**WELWYN HATFIELD BOROUGH COUNCIL – DEVELOPMENT MANAGEMENT**  
**DELEGATED REPORT**

<b>APPLICATION No:</b>	<b>N6/2013/1769/AD</b>
<b>APPLICATION Site:</b>	<b>Stanborough Inn , Stanborough Road, Welwyn Garden City</b>

This application seeks advertisement consent for the erection of a free standing illuminated totem sign.

Site Plan

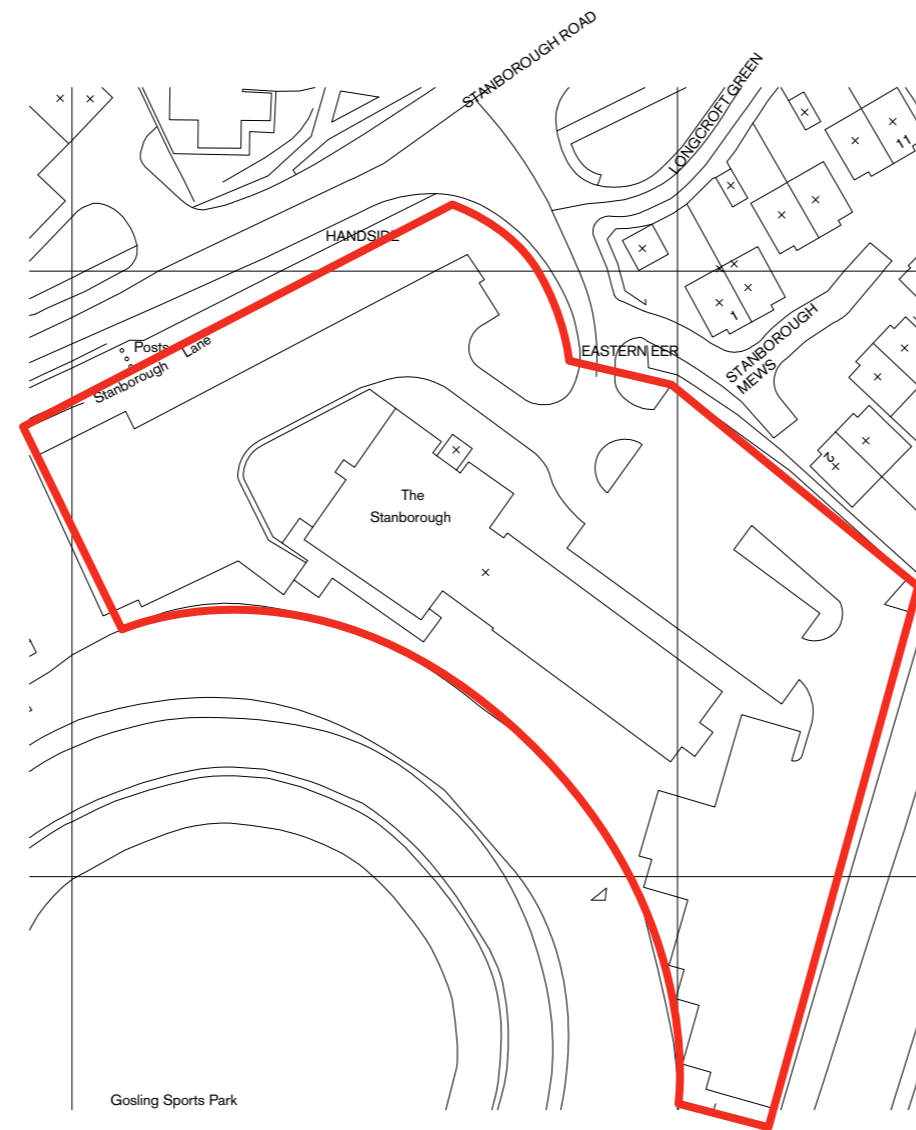
The proposed sign would have a height of 4.5m and would be located with two other existing signs at the site. The existing signage is relatively large and includes a totem sign of similar proportions to that proposed. The proposal would be visible from Stanborough Road and would be seen from both directions when travelling along the road.

Whilst the signage itself would not be that unreasonable along such a main road on its own, it is considered that the amount of signage that would result at the site, two of which would be illuminated totem signs adjacent to each other, would overburden this part of the street scene. Additionally as a result they would be unduly prominent when travelling along this road and creating visual clutter to the detriment of the character of the street scene.

Totem 4.5m

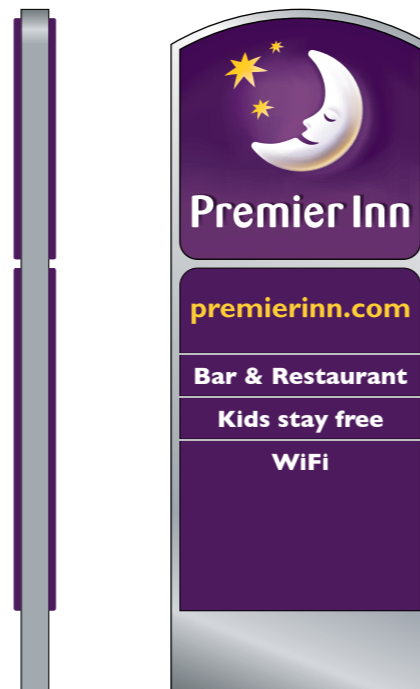
In addition, the sign would be illuminated and whilst the level of luminance is 250cd/m<sup>2</sup> which complies with the recommendations in the Institution of Lighting Engineers, this would further emphasise its presence within the street scene of Stanborough Road, detracting from the character and appearance of the area.

Subsequently it is considered that a further totem sign, so close to an existing totem sign, is unsuited to the local context and would detract from the visual amenities of the locality. This would be an unacceptably harmful and discordant element within the street scene, detrimentally disrupting its visual rhythm, contrary to the NPPF and policies GBSP2, D1 and D2 of the District Plan and the Council's SDG.

However the applicant should be made aware that the proposed signage would be located within the public highway and such a location would require licensing by the highway authority. Although there is no technical reason to object to the sign subject to the proposals put forward.

1. By virtue of the number of signs already at the site together with the siting, scale and illumination of the proposed totem sign, the proposal would result in a more cluttered appearance of the street scene of Stanborough Road that would be detrimental to the character and visual amenity of the surrounds. This would fail to be compatible with the maintenance or enhancement of the character and appearance of the area as stated in policy GBSP2 of the Welwyn Hatfield District Plan, 2005. The proposed development would therefore be contrary to the National Planning policy Framework and Policies GBSP2, D1 & D2 of the Welwyn Hatfield District Plan and Part 6 of the Welwyn Hatfield District Plan, Supplementary Design Guidance, Statement of Council Policy, 2005.
